PLANNING BOARD REPORT

Commercial Development including gas station and convenience store with ATM

2282 Congress Street

Project ID #2013-086

PLAN 8

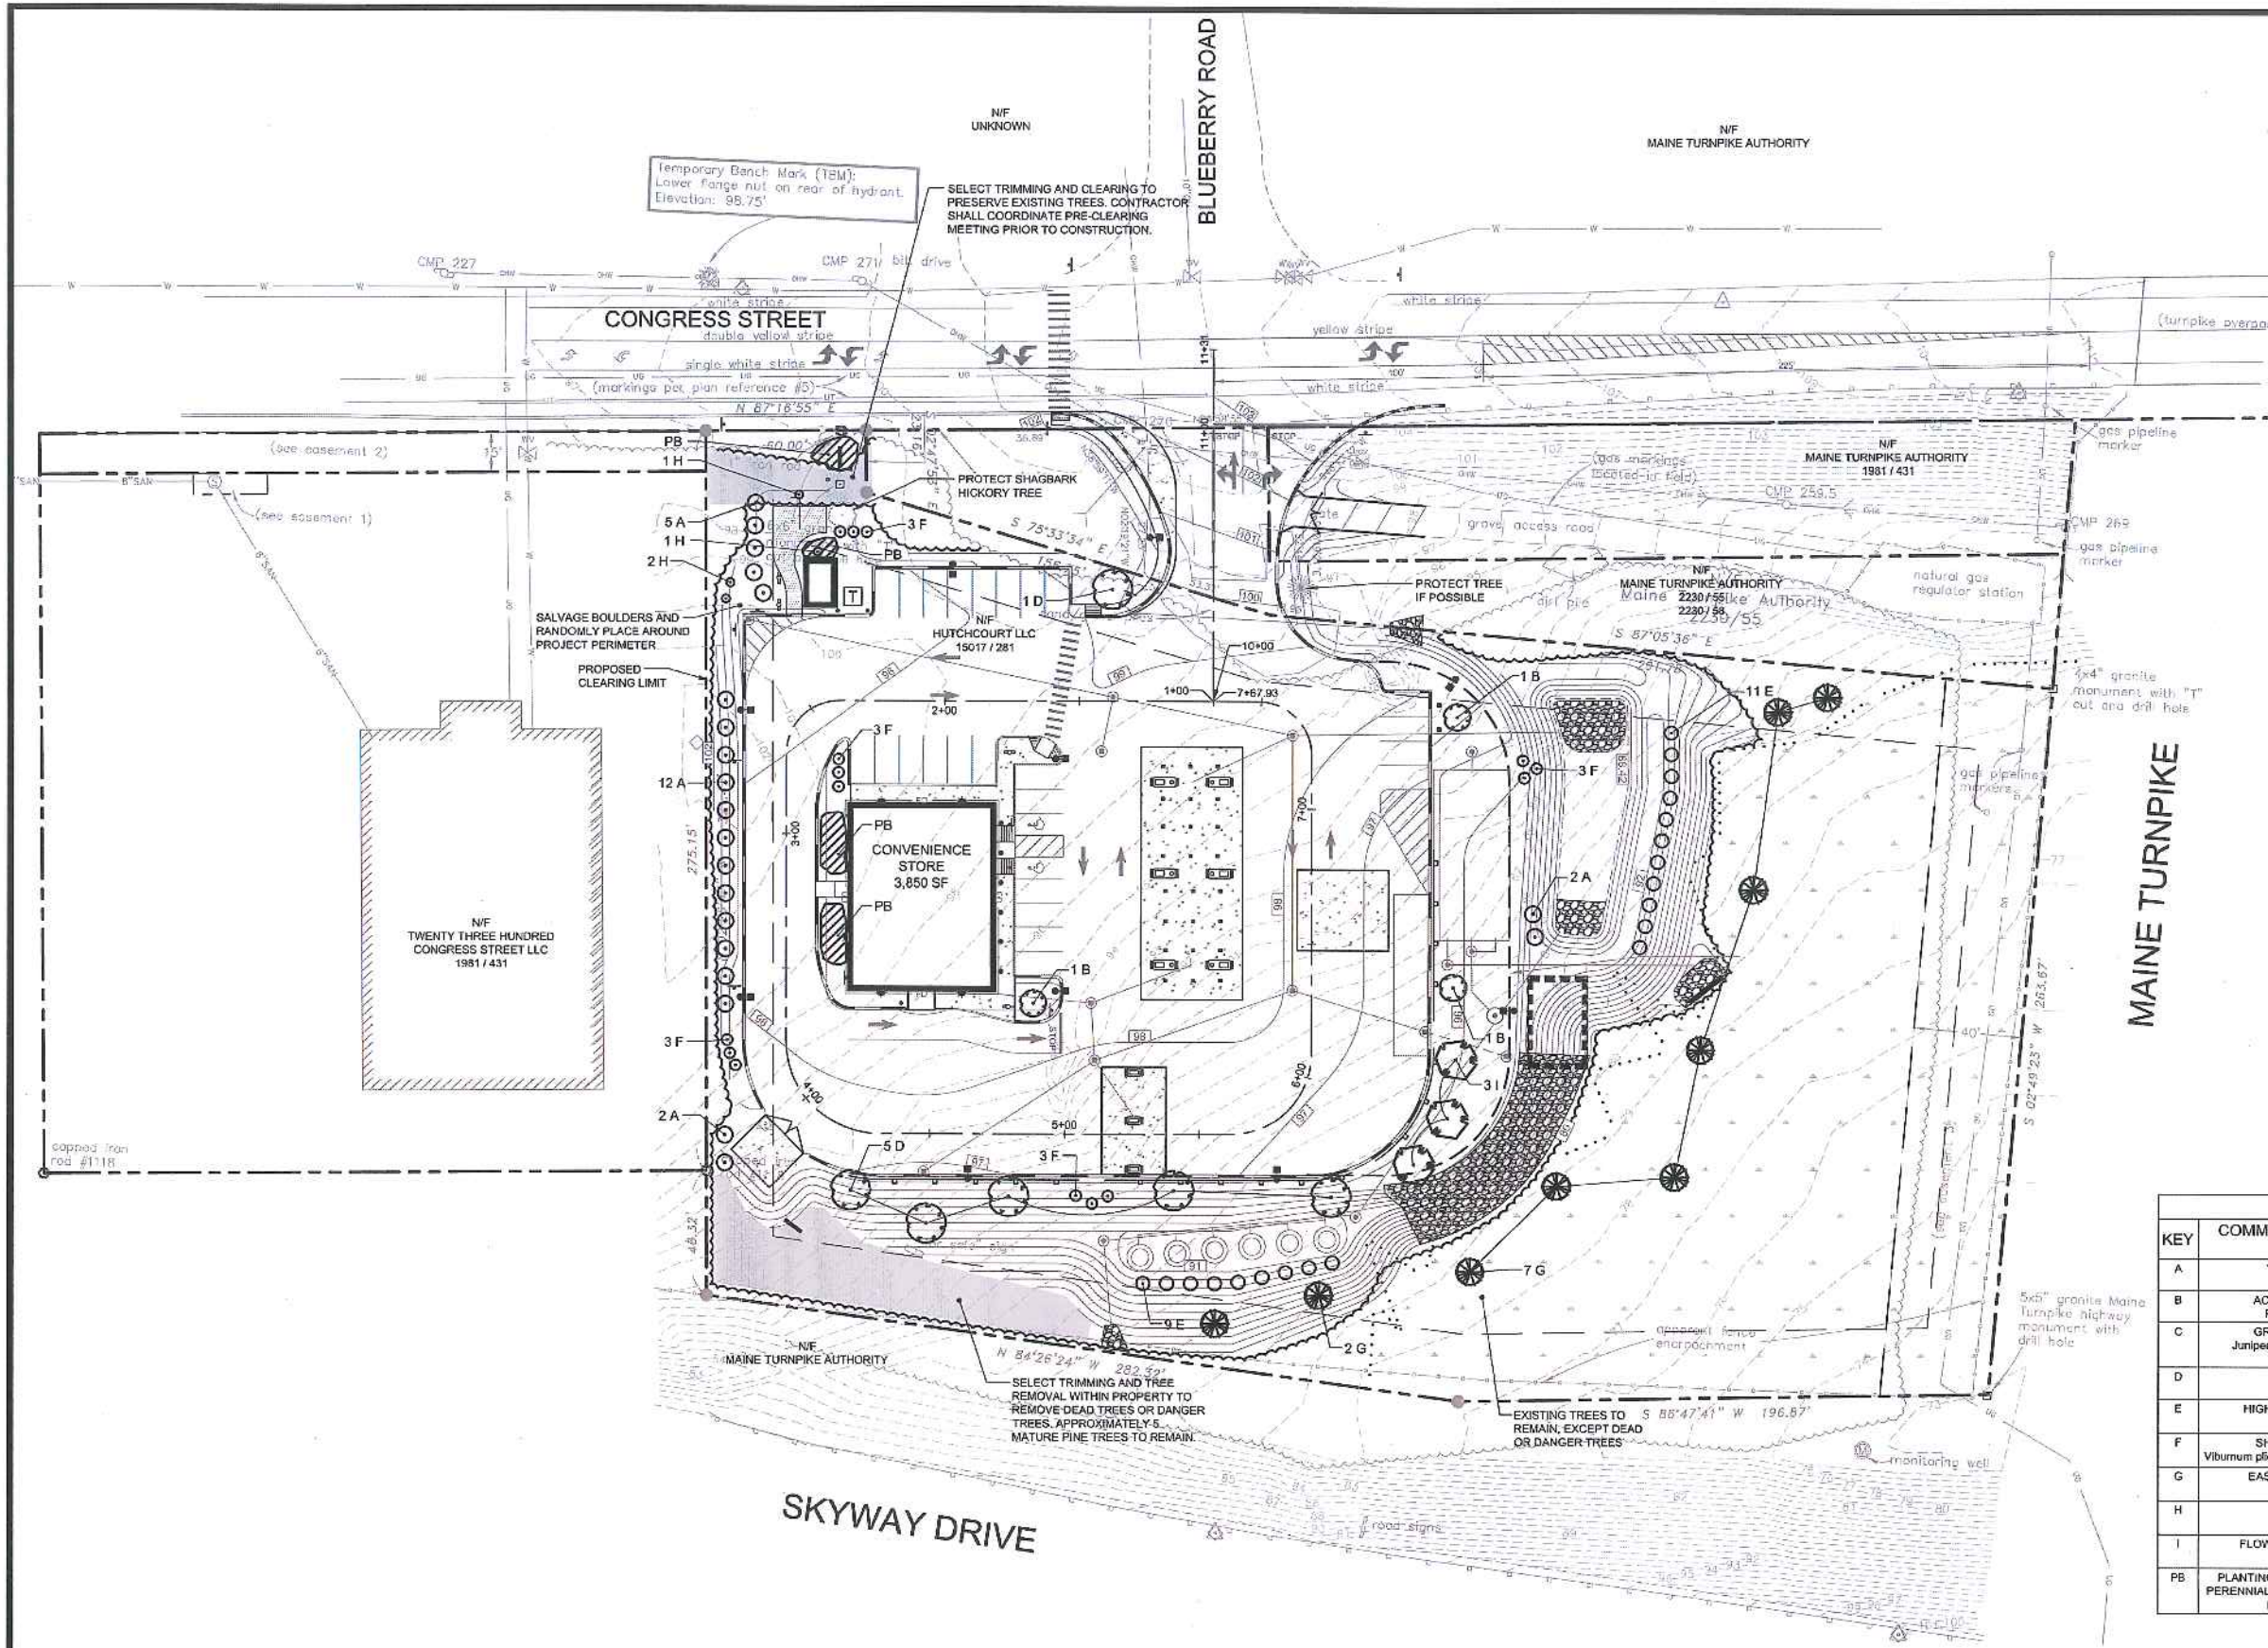
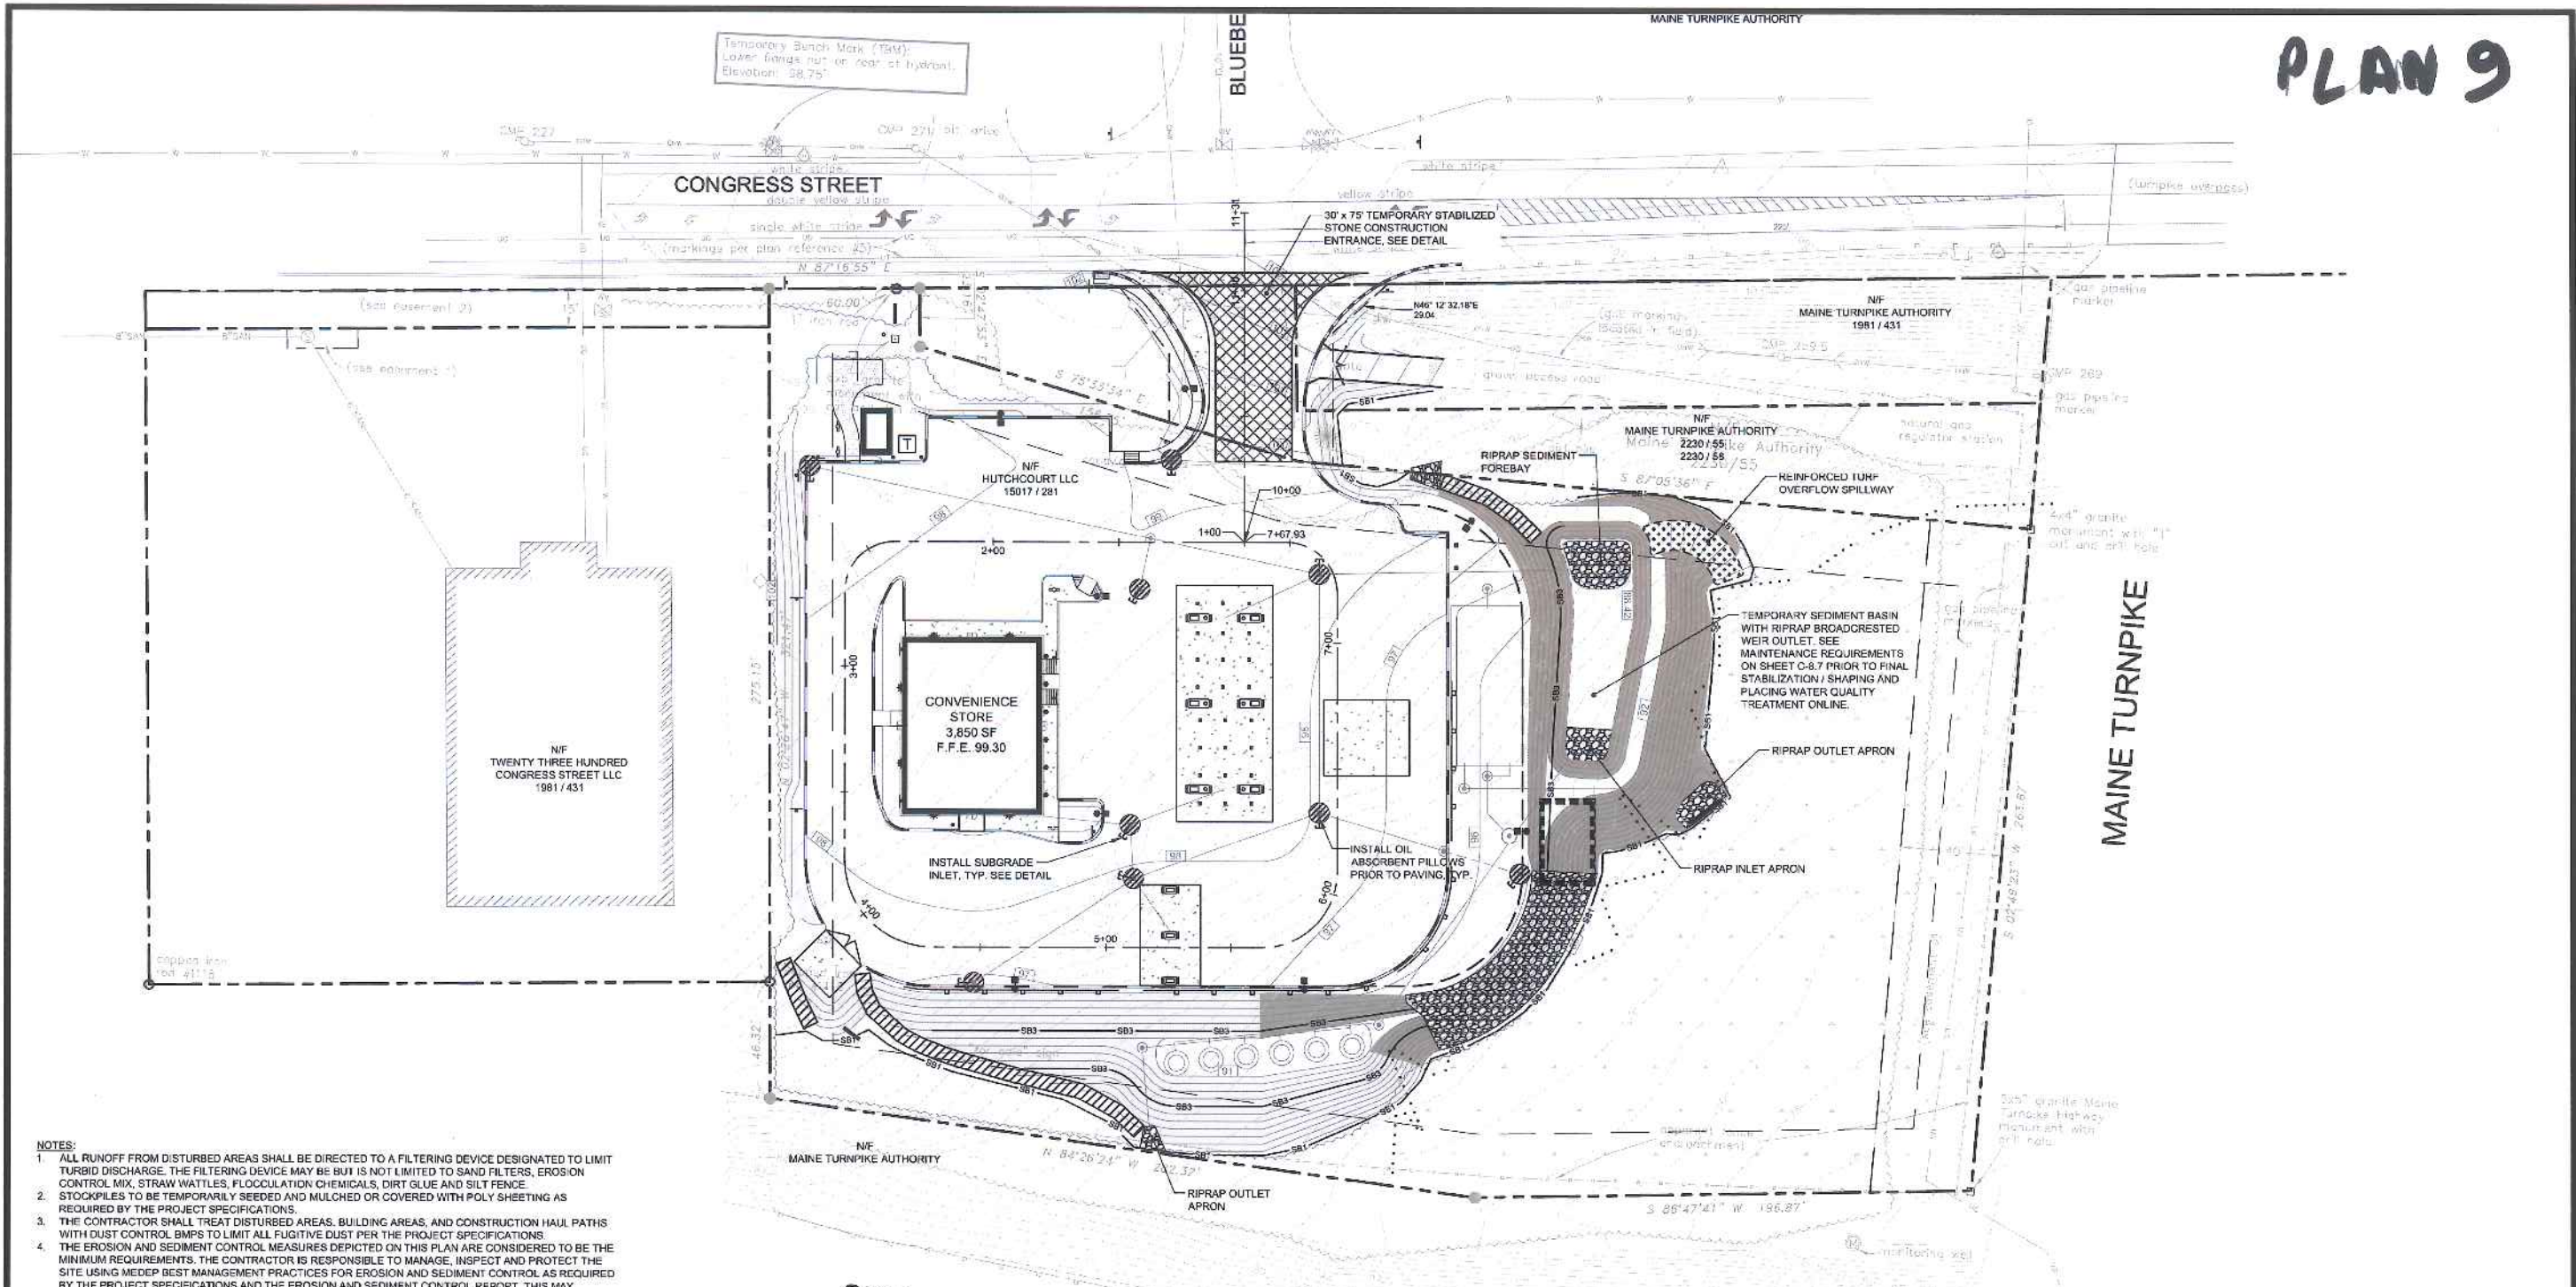
The final Landscape Plan (Plan 8) reflects a number of improvements (relocation of the dumpster; addition of the farmstand and landscaped area near Congress Street, more extensive buffer planting). However, the City Arborist, Jeff Tarling, has two small recommendations to address both the CZA objective of achieving a “campus like character” and the site plan ordinance requirements for retaining trees (Attachment 8):

a) Tree Save - the 'tree-save', tree thinning area along Congress Street is improved and meets our recommendations. Additional 'tree-save' areas along the Western property line and towards Skyview Drive will need to be marked prior to site work and as approved by the City Arborist. There may be trees to be thinned or removed due to poor condition or risk. (Thinning trees for views is not recommended - thinning trees for safety and condition is.) Standard tree protection measures shall be used during construction, these include protection of tree root zones, identifying trees to protected, construction fencing or tagging where needed. No storage of equipment or construction materials in tree protection root zone areas. The area around the Shagbark Hickory is one of the tree protection zones.

b) Trees in parking lot - In the area shown as snow storage, and addition one to two trees could be set back away from the edge of pavement to still allow snow clearing and meet the parking lot tree / shrub standards.

A potential condition of approval includes these recommendations.

CANOPY ELEVATIONS
A2

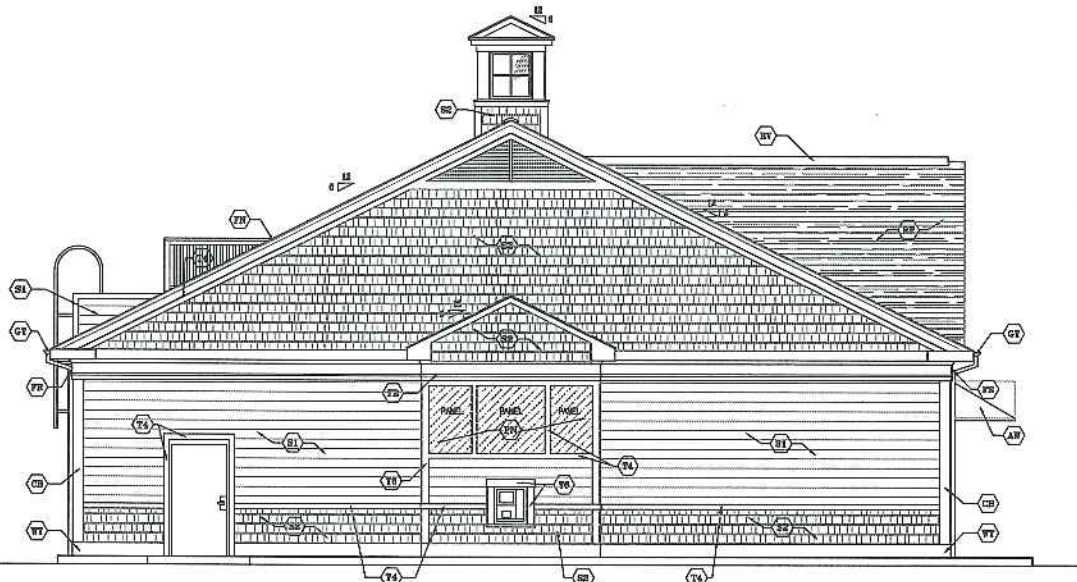
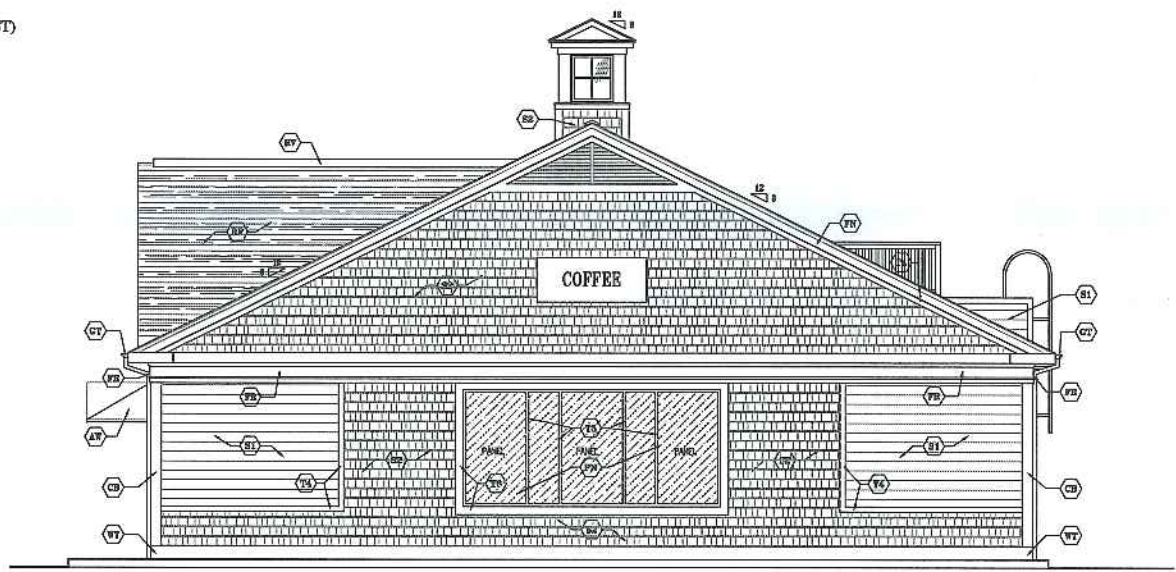
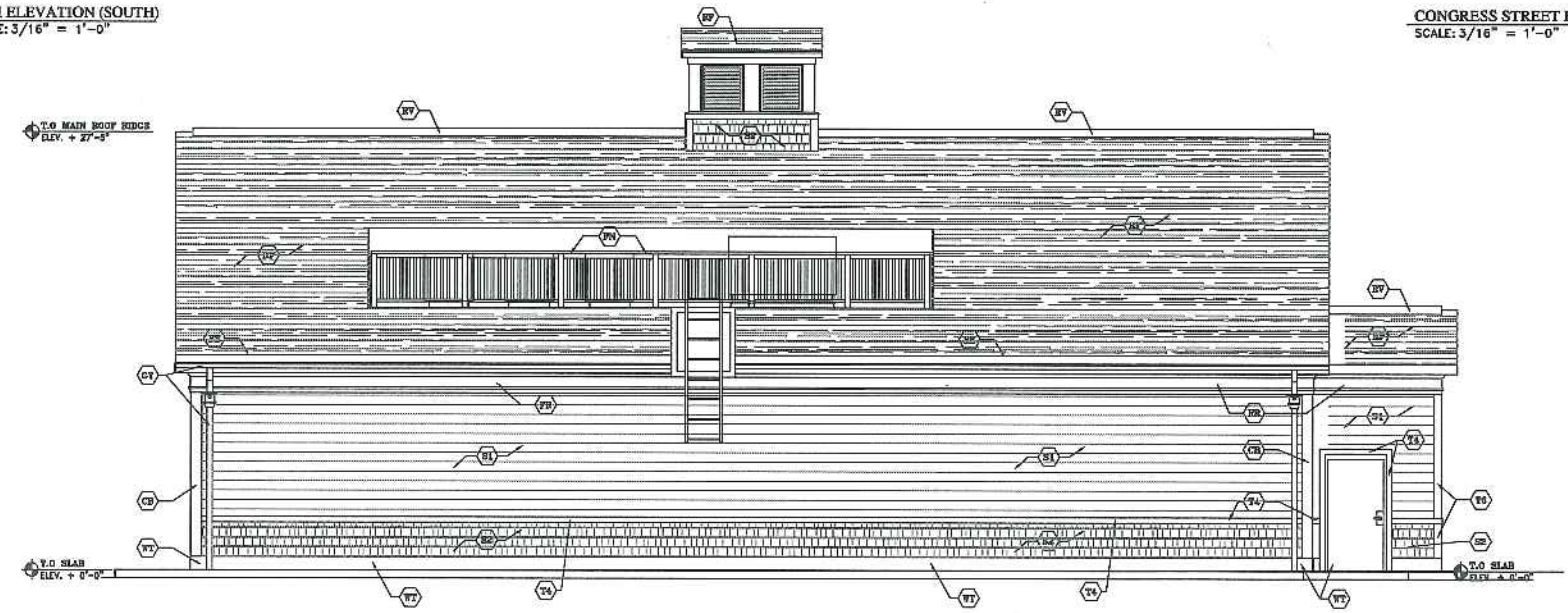
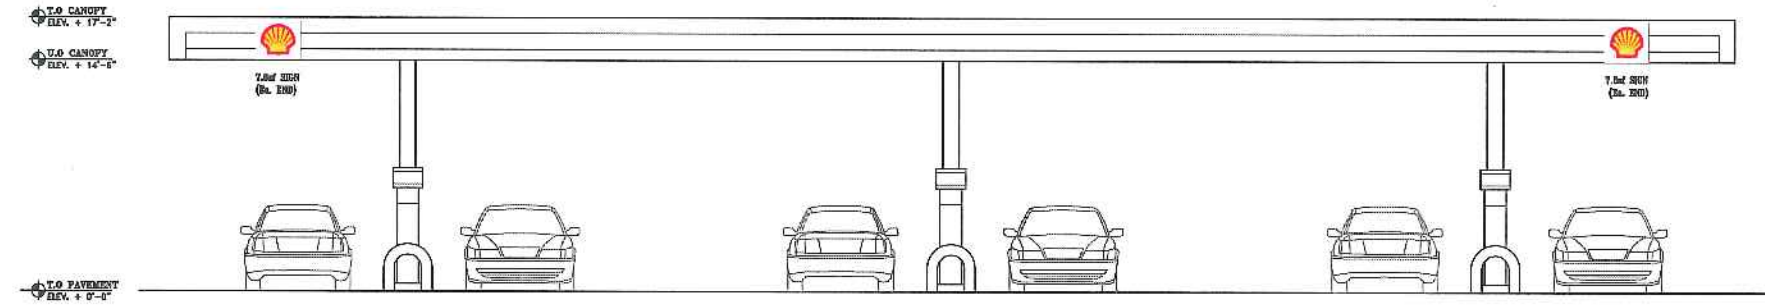
Staff comment: The bank drive through is no longer part of the proposals. The site plan has addressed landscaping, and protection of pedestrians as discussed under the Site Plan review. The elevations of the proposed convenience store and gas station canopy are included in Plans 25 and 26.

Staff comment: The proposed architecture (Plans 25 and 26) appears to be consistent with a campus like character. Board will need to consider whether the landscaping (which staff recommends should be augmented near the truck parking area) and the light fixture ("Prolific", see Attachment I.4) is consistent with the aim to achieve a campus like character (both discussed in Site Plan Review below)
